# Rezoning Transportation Analysis

Petition Number: 2023-033

**From:** Jake Carpenter, PE  
Jacob.carpenter@charlottenc.gov  
980-221-5675

**Reviewer:** Natalie King  
Natalie.King@charlottenc.gov  
980-417-0206

RZ1-00

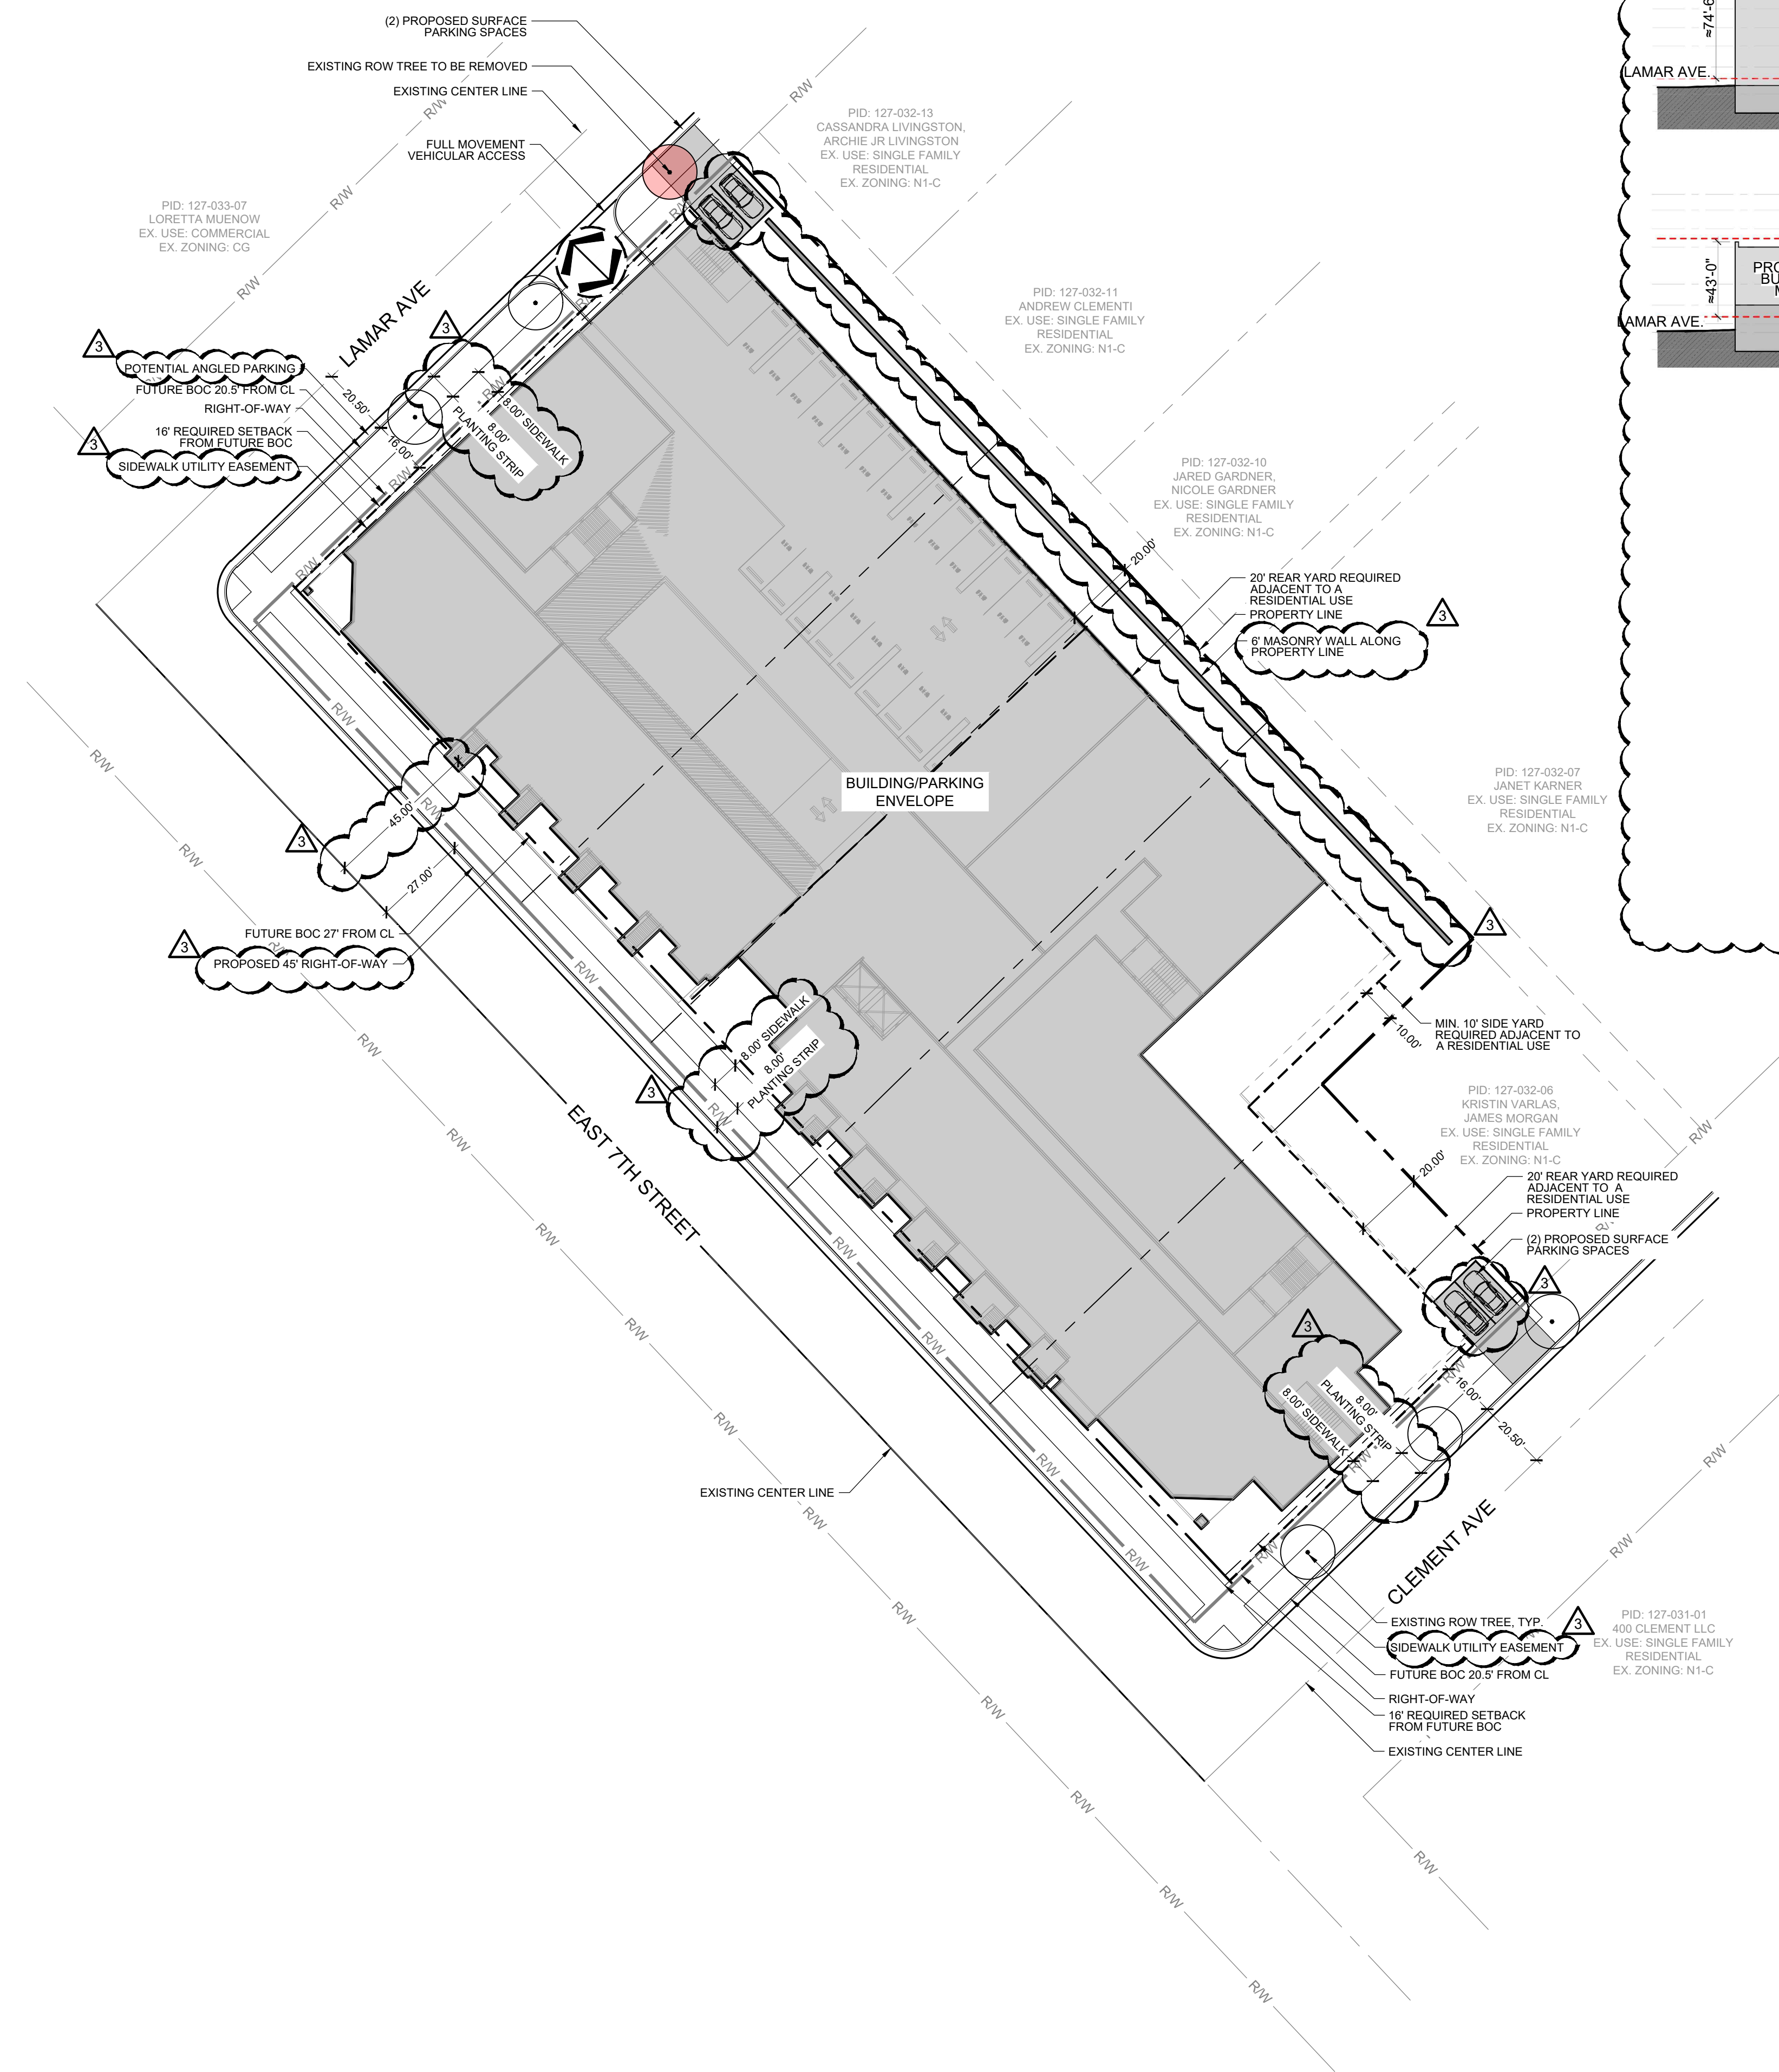
**Clarifying Comment 9-20-23:** Remove the additional parking spaces on Clement and Lamar Ave. Access to parking spaces is not allowed over a streetscape. This access would be considered a driveway and would be required to meet minimum driveway standards including geometric design, spacing, and internal stem requirements.

**Clarifying Comment 8-24-23:** Sidewalk must be located within ROW or a sidewalk utility easement, which must extend an additional 2-feet behind sidewalk. Site plan shall label and dimension ROW/SUE. If a sidewalk utility easement is utilized, include a conditional note regarding commitment to placing sidewalk within easement.

**RZ1-00**

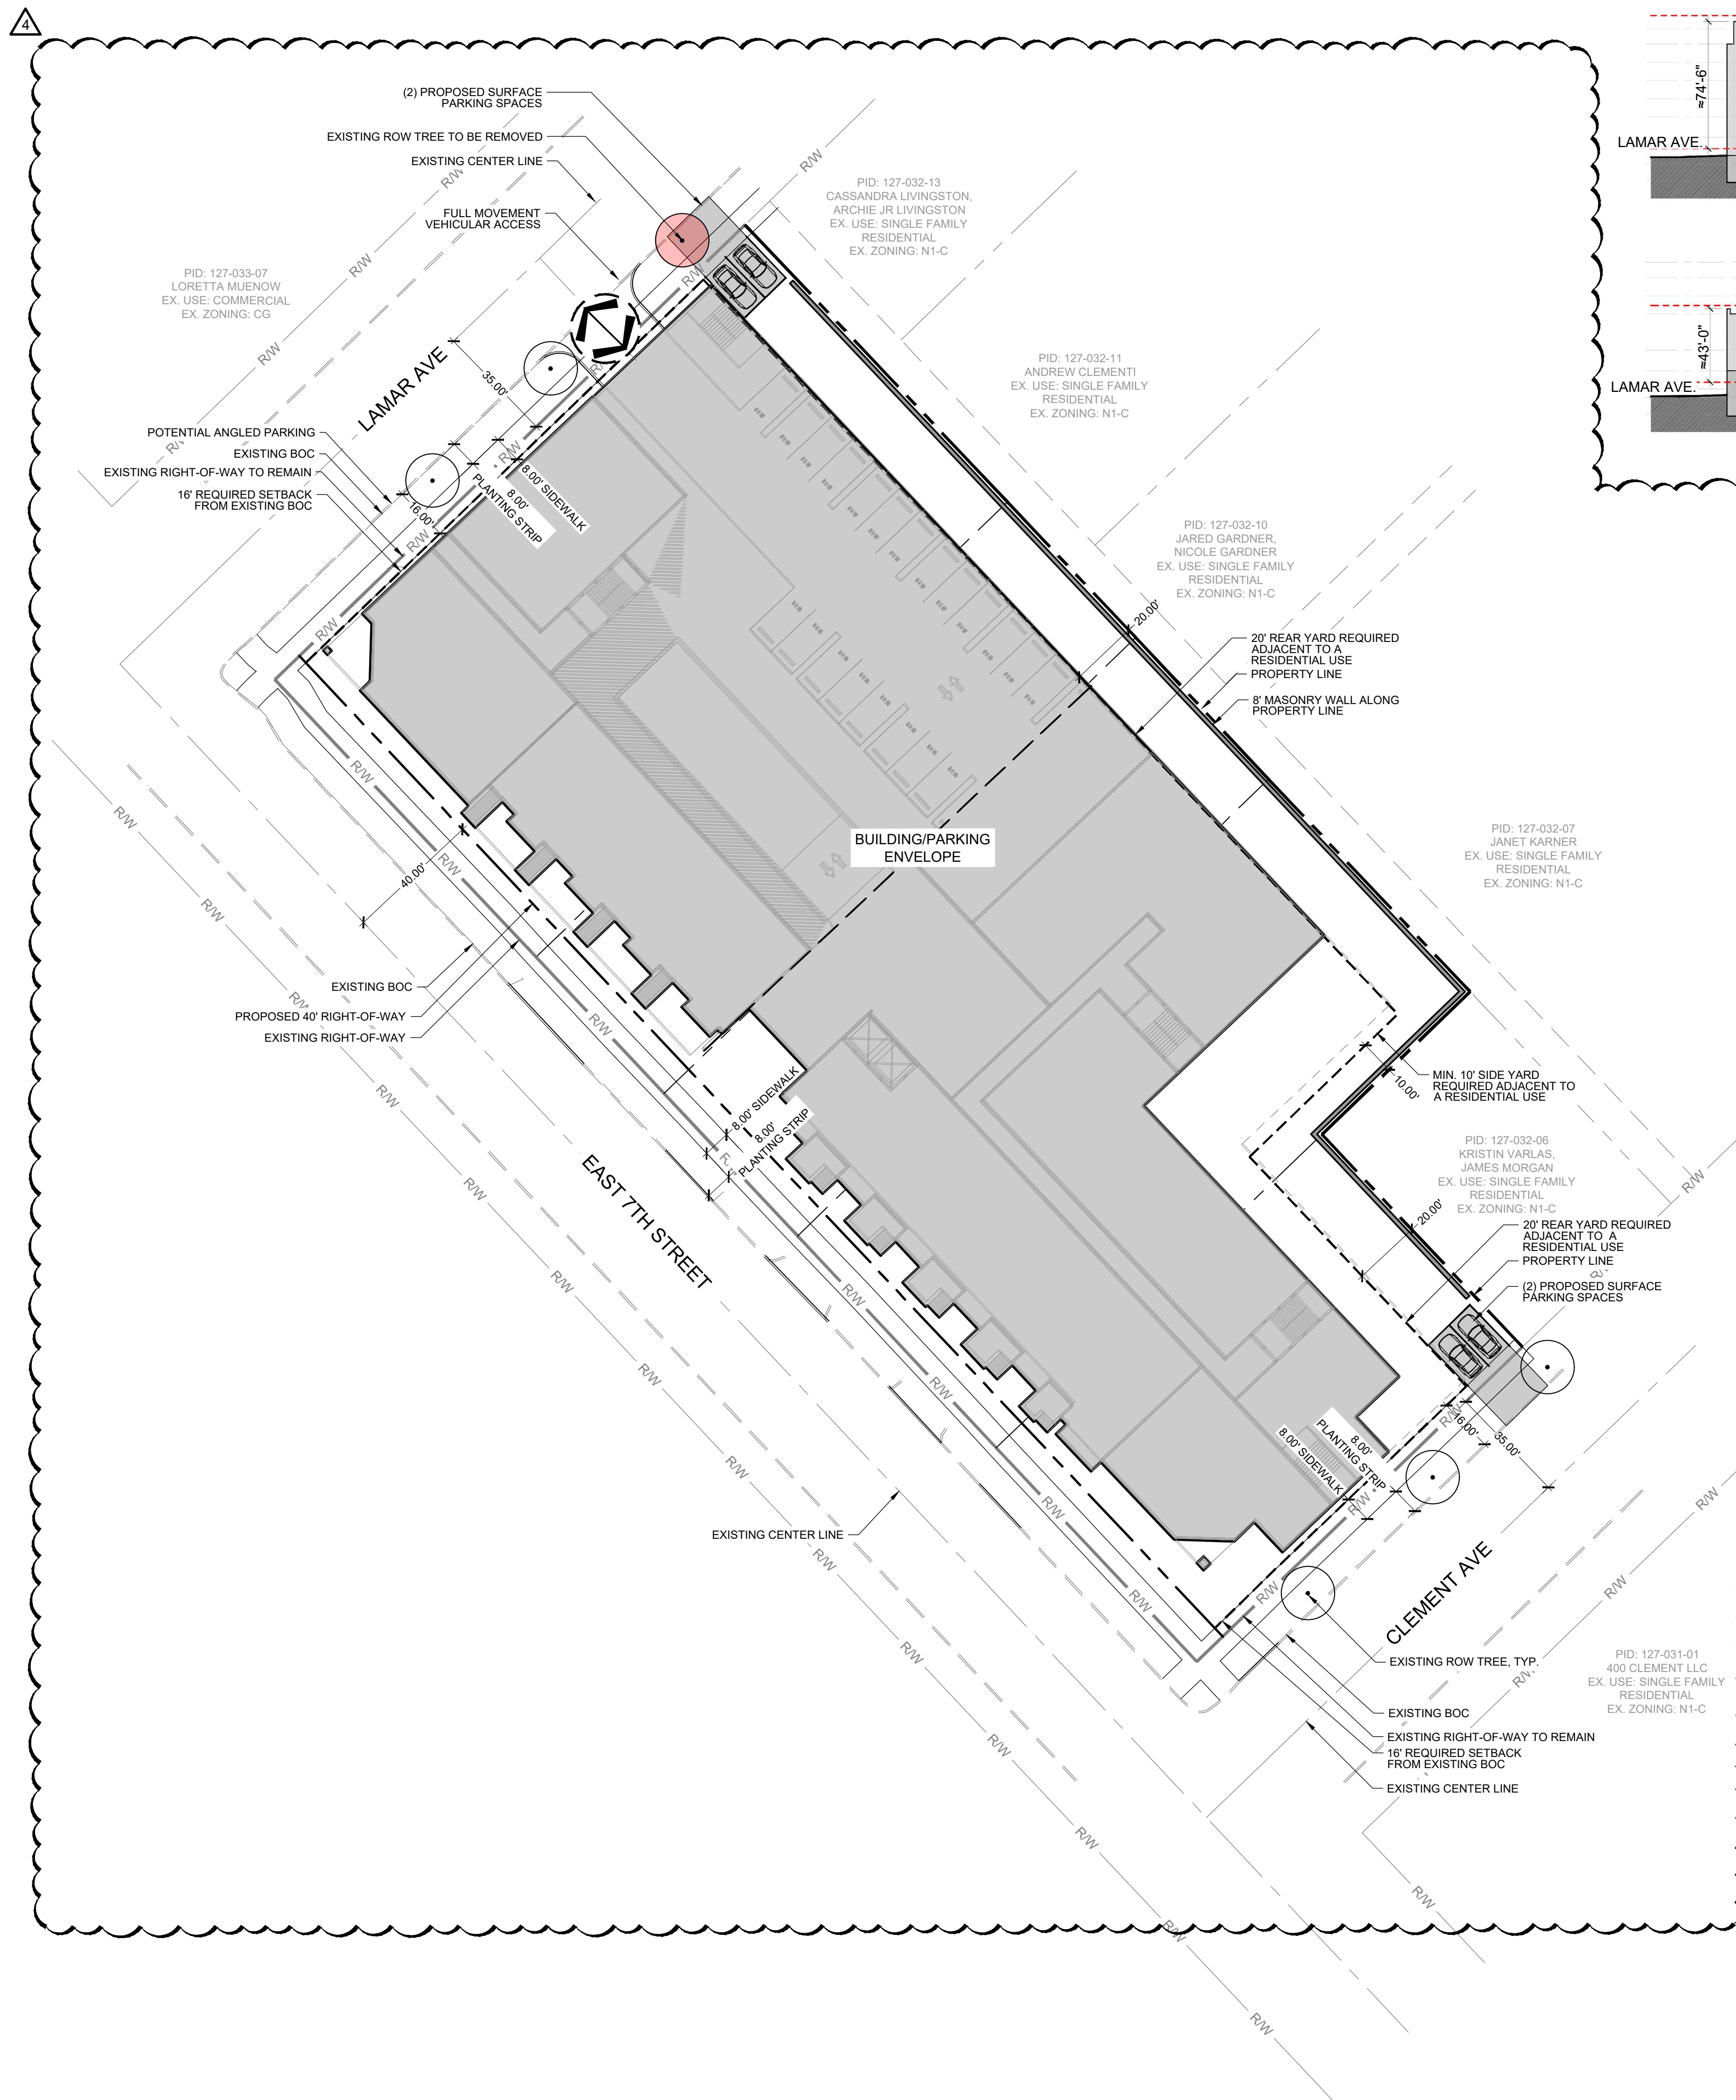
13. **New Comment 10-26-23:** Revise site plan to show future curb line located 27’ from centerline of E. 7<sup>th</sup> Street. Preservation of future curb line allows installation of bicycle facilities in the future to include buffered bicycle lanes. Preservation of space for future buffered bicycle lanes meets Council-adopted Charlotte BIKES policy. Current plan revision removed preservation of space for bicycle facilities and does not accommodate any form of future bicycle facilities.

14. ~~New Comment 9-20-23:~~ Revise site plan to eliminate encroachment of building and building entrances into the right of way.

15. ~~New Comment 10-26-23:~~ Remove reference to potential angled parking. Angled parking not permitted within the public right of way. Petitioner may work with CDOT during the permitting process to stripe parallel parking if desired.
